PROJECT: LEE 5, 45 HONEYSUCKLE DRIVE, NEWCASTLE

RE: SDRP3 – Third Review – 11.04.19

North Elevation
Scale: 1:200

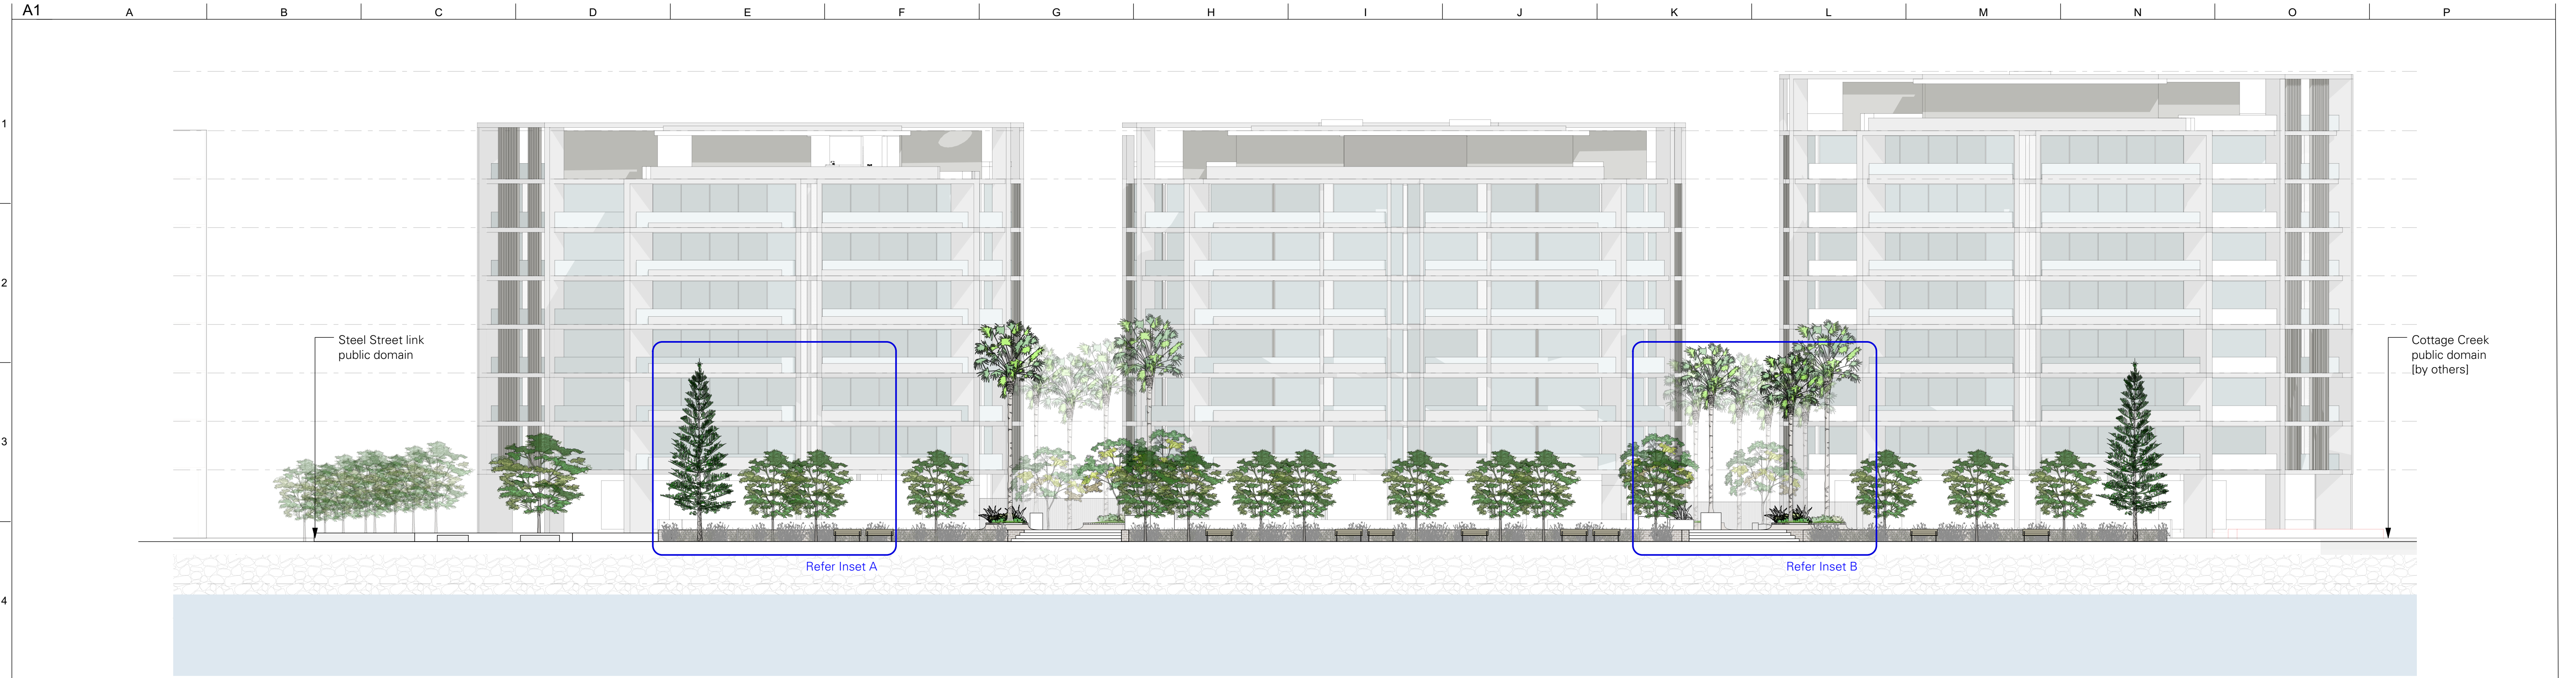
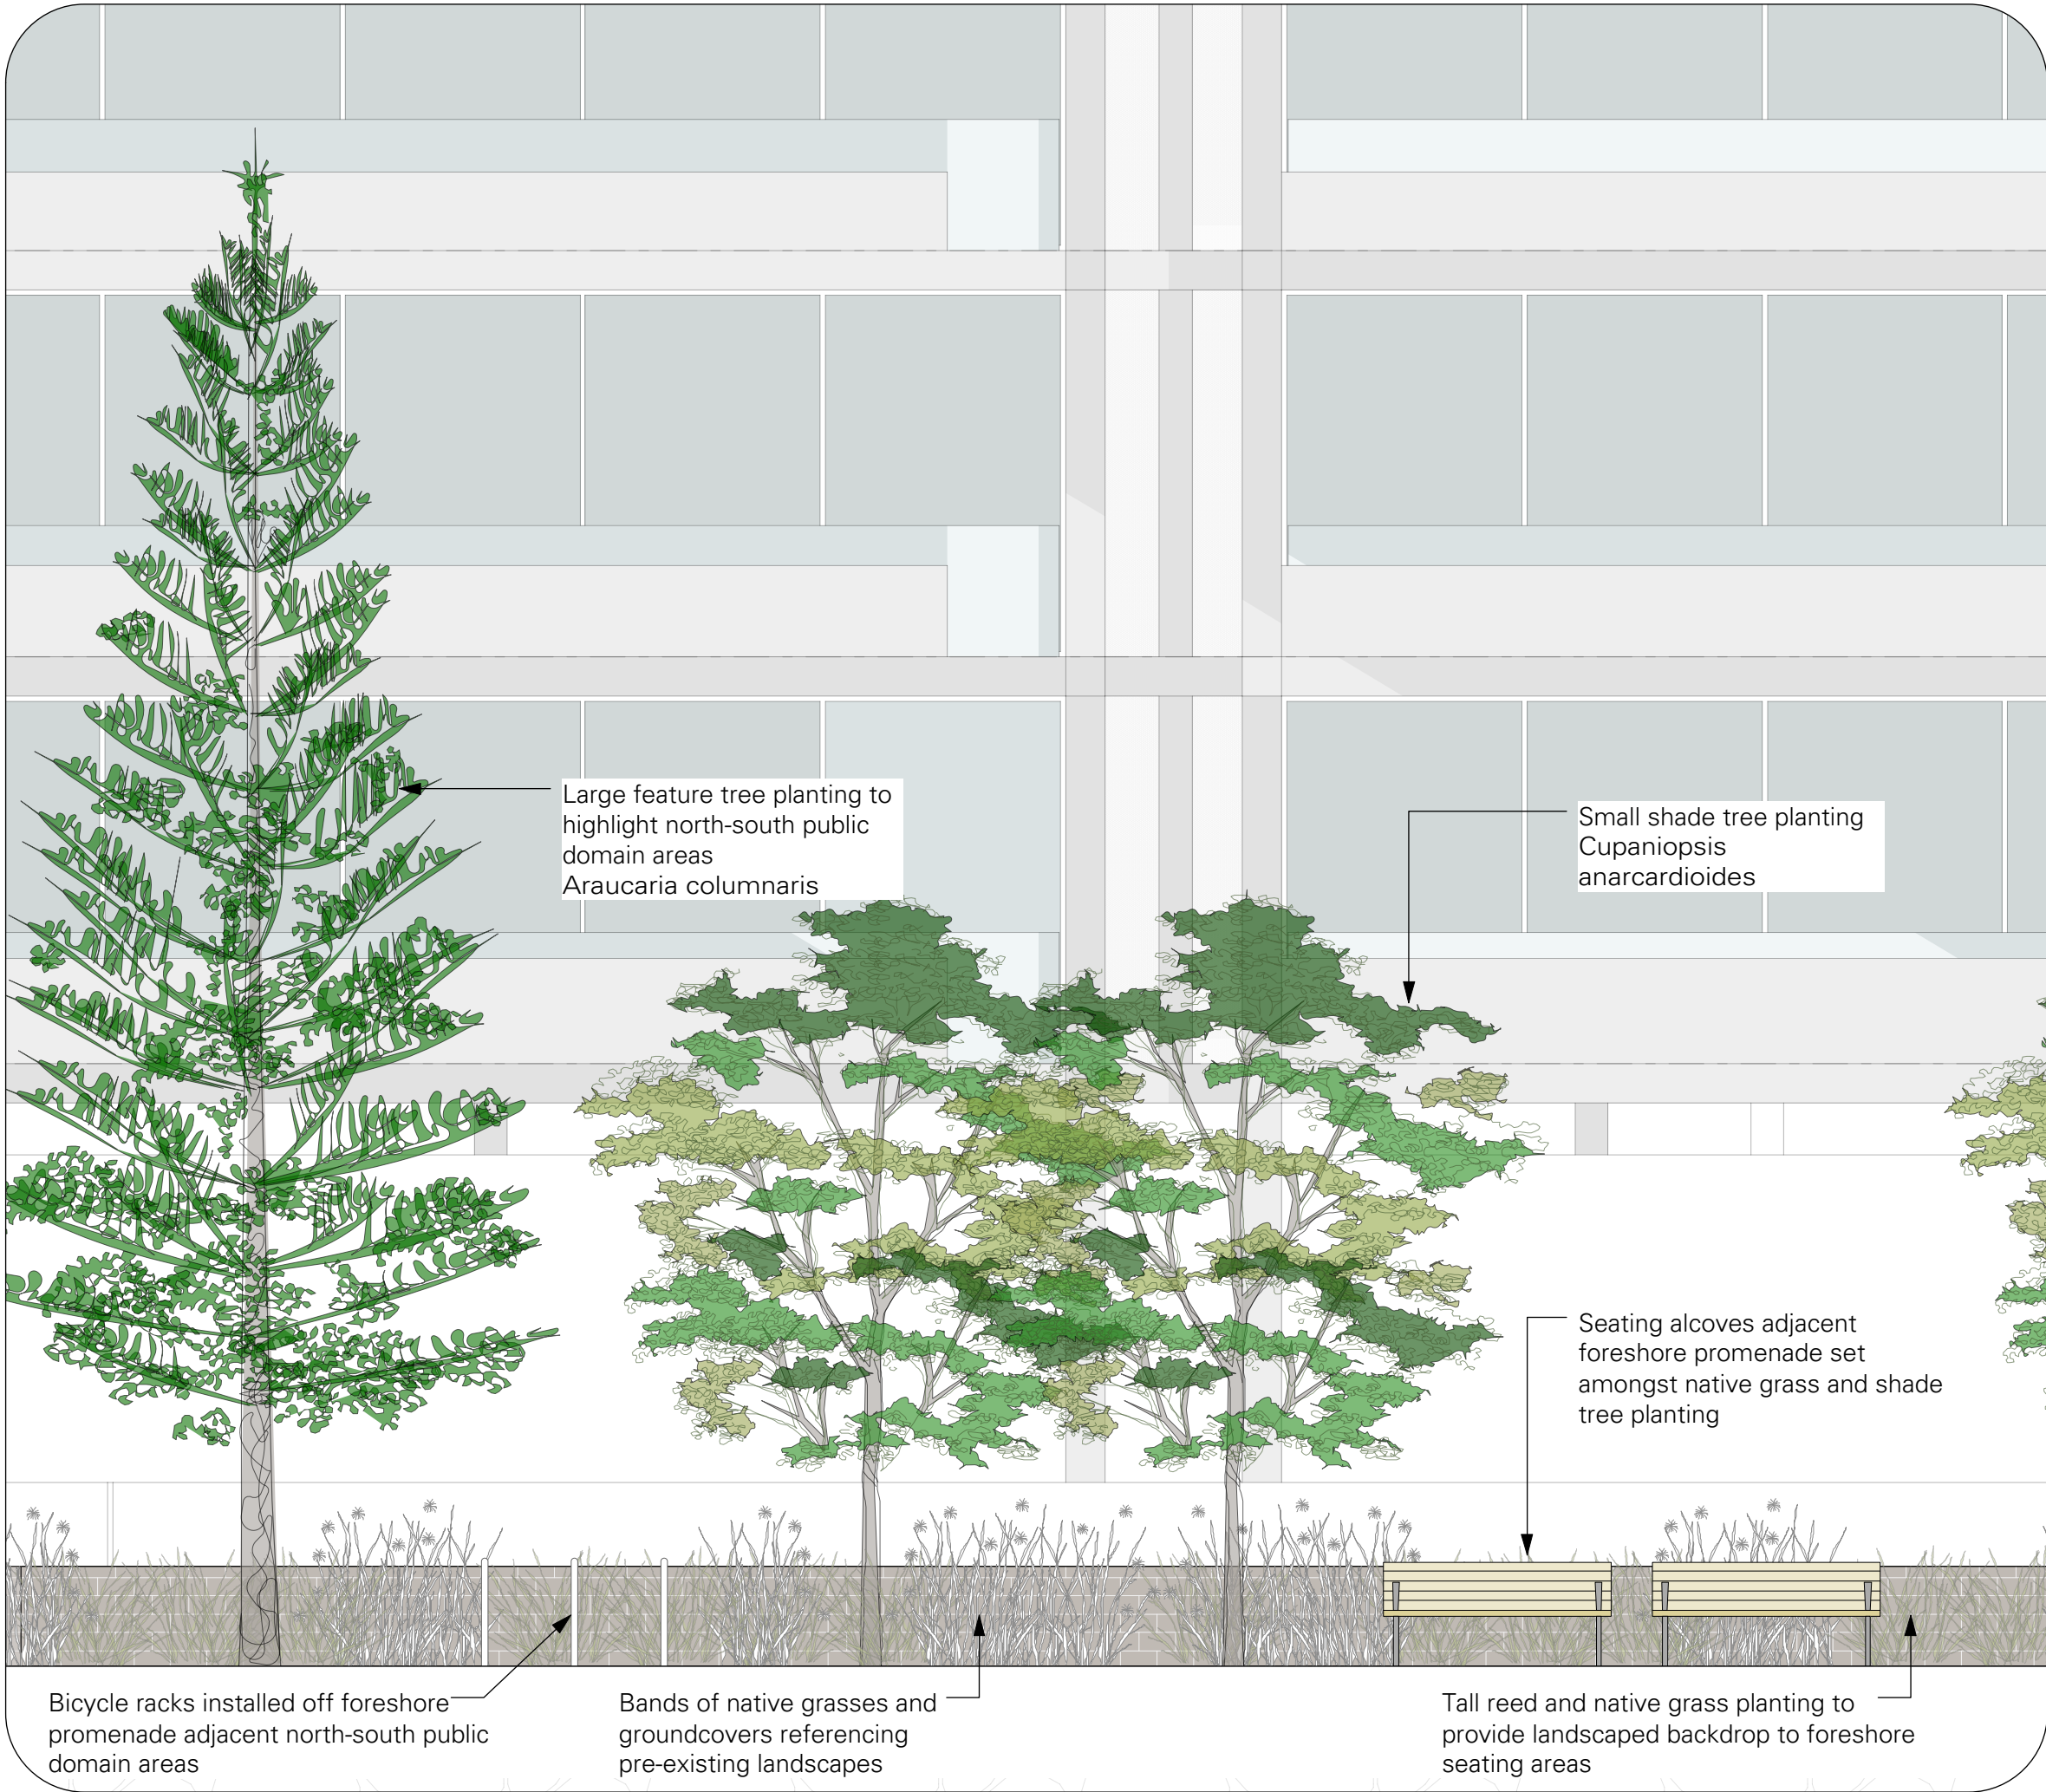
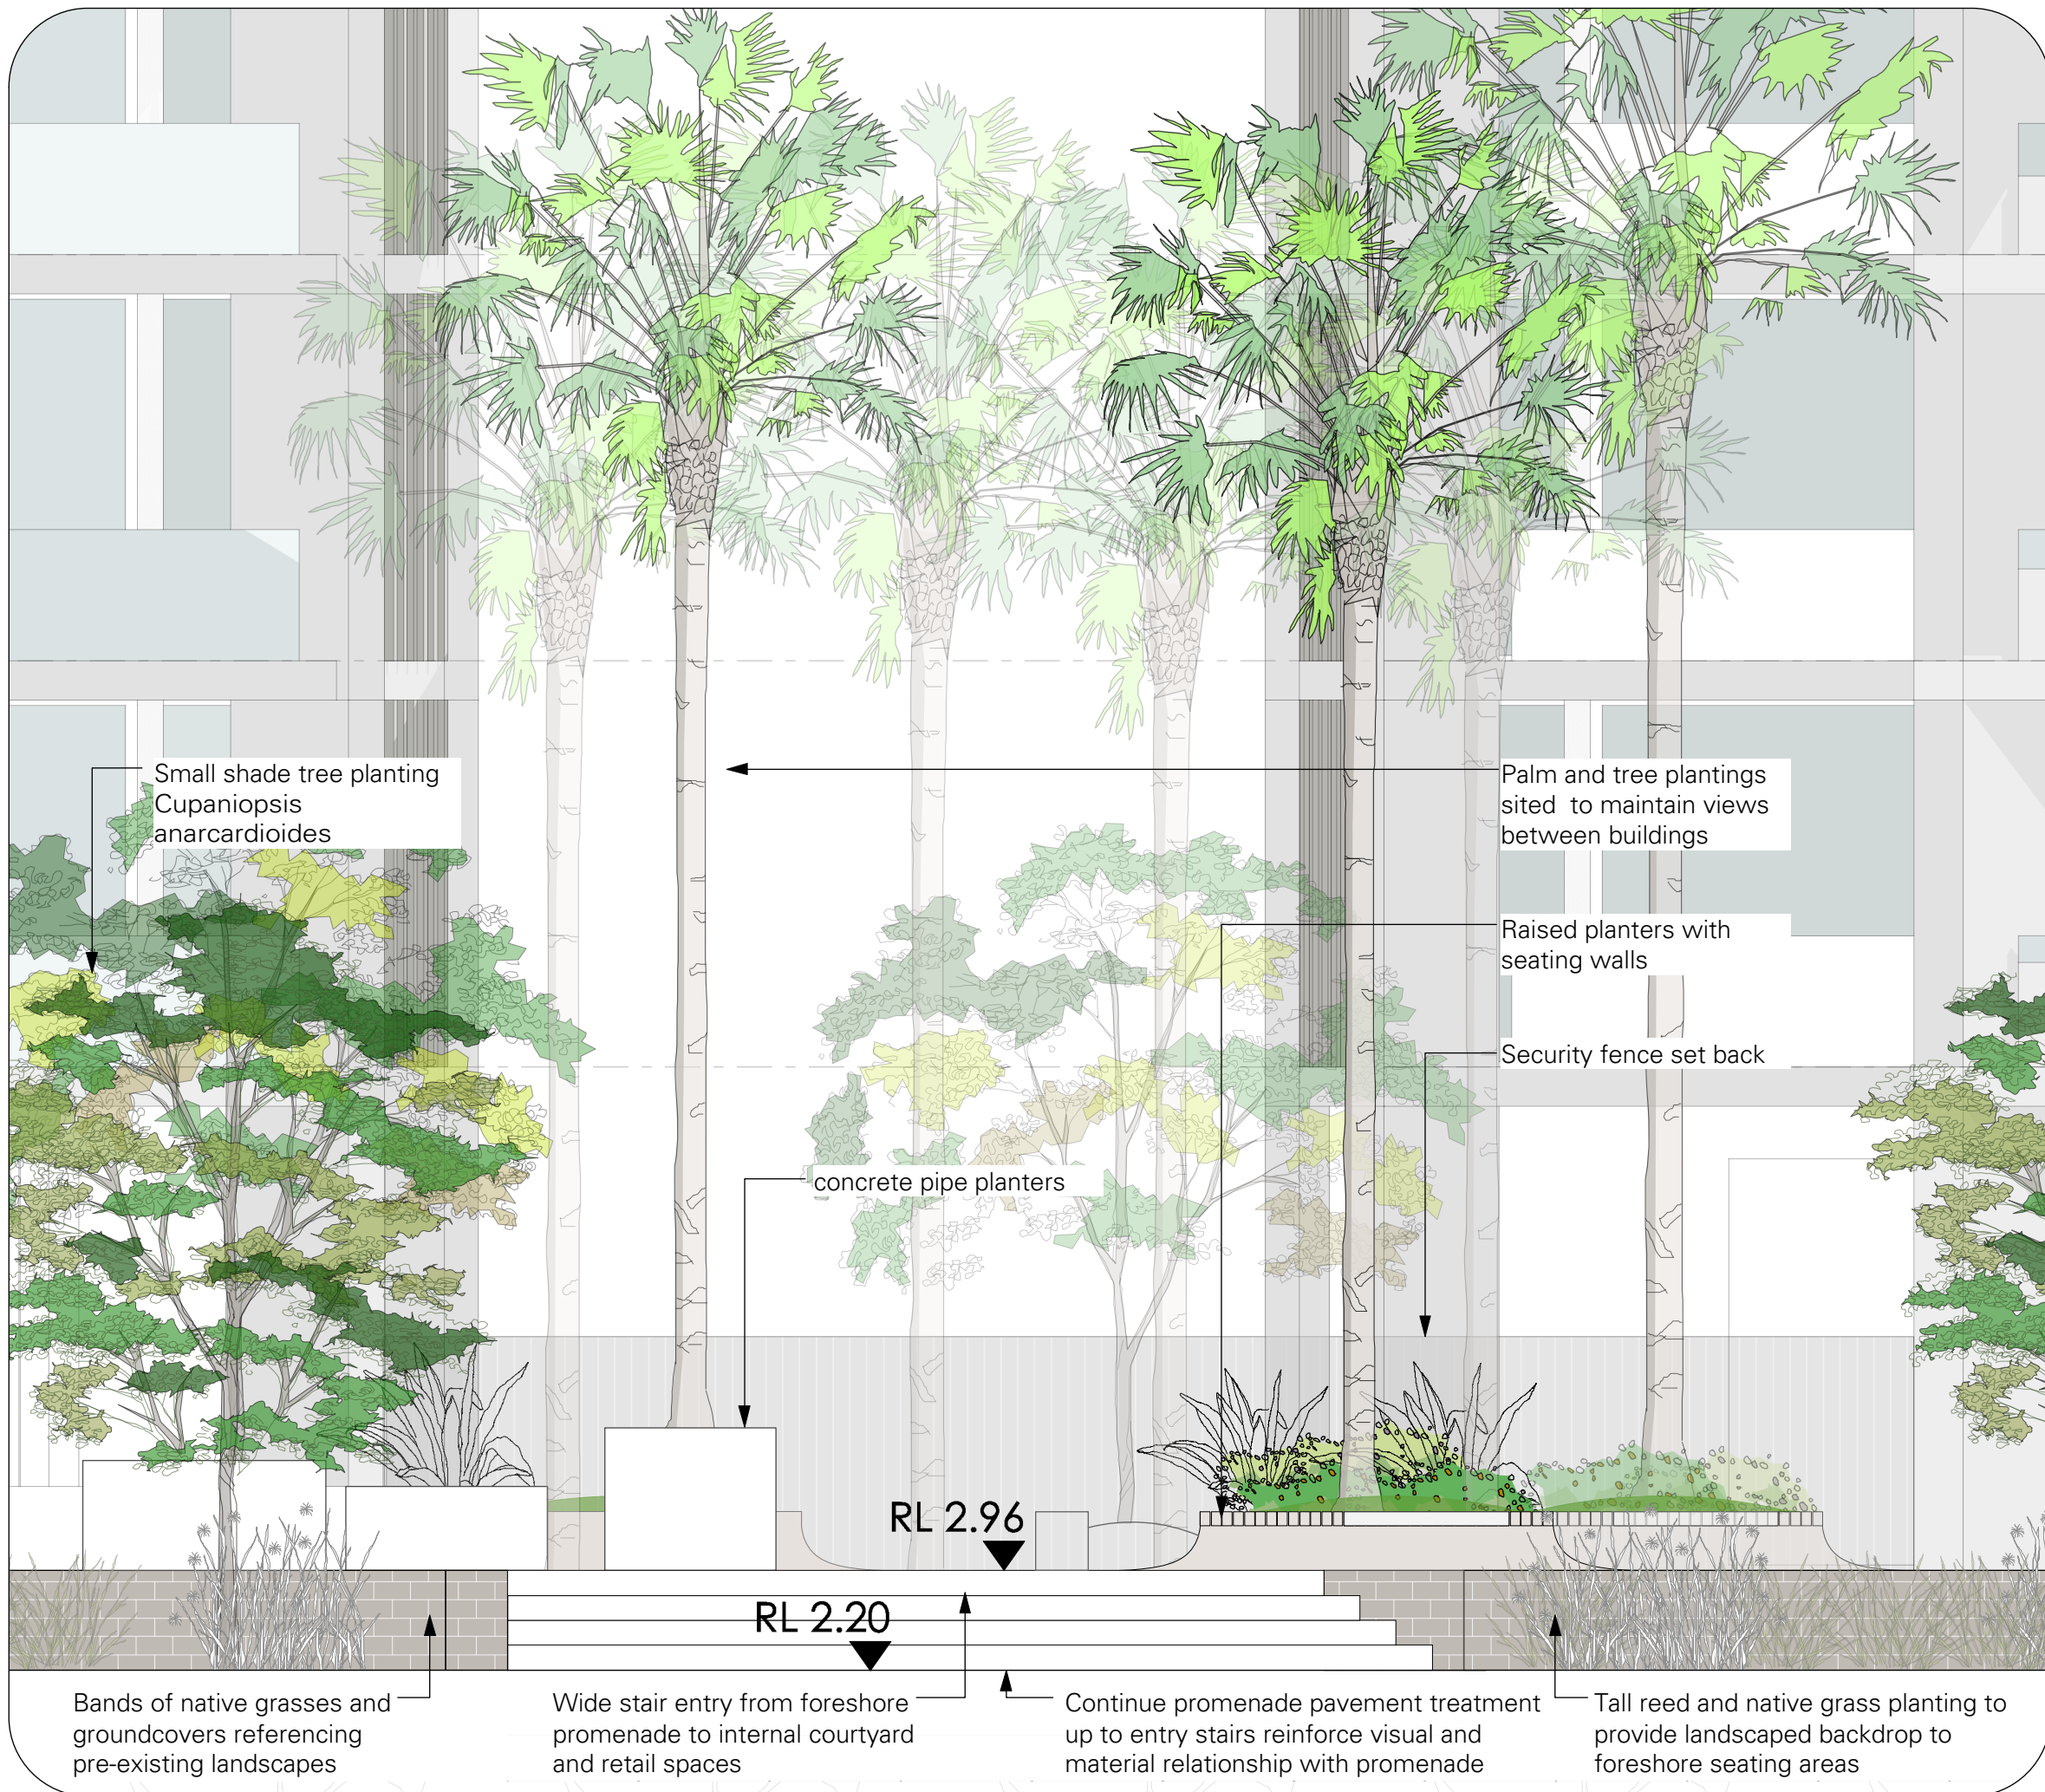
The articulated concrete structure is a successful strategy overall but requires further resolution at the main entry off Honeysuckle Drive. Provide elevations and 3D views to illustrate.

Proposed landscape character

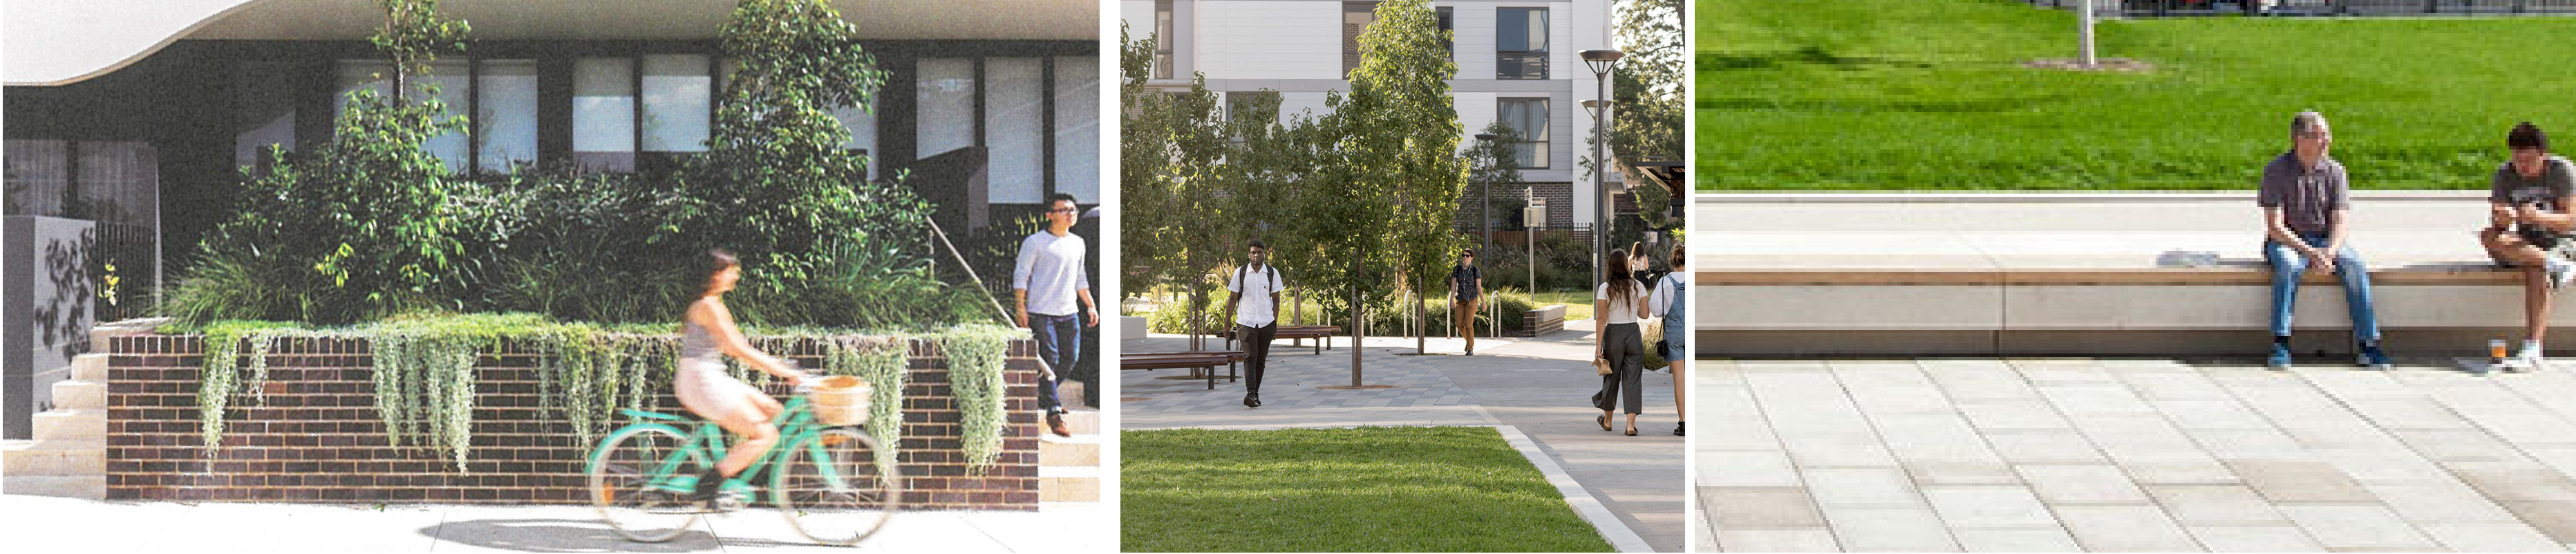
Further resolution and additional details are requested for the courtyard areas and the planter boxes along the foreshore. As currently illustrated the courtyard areas present as overly rigid in relation to the articulation of the building at the ground plane.
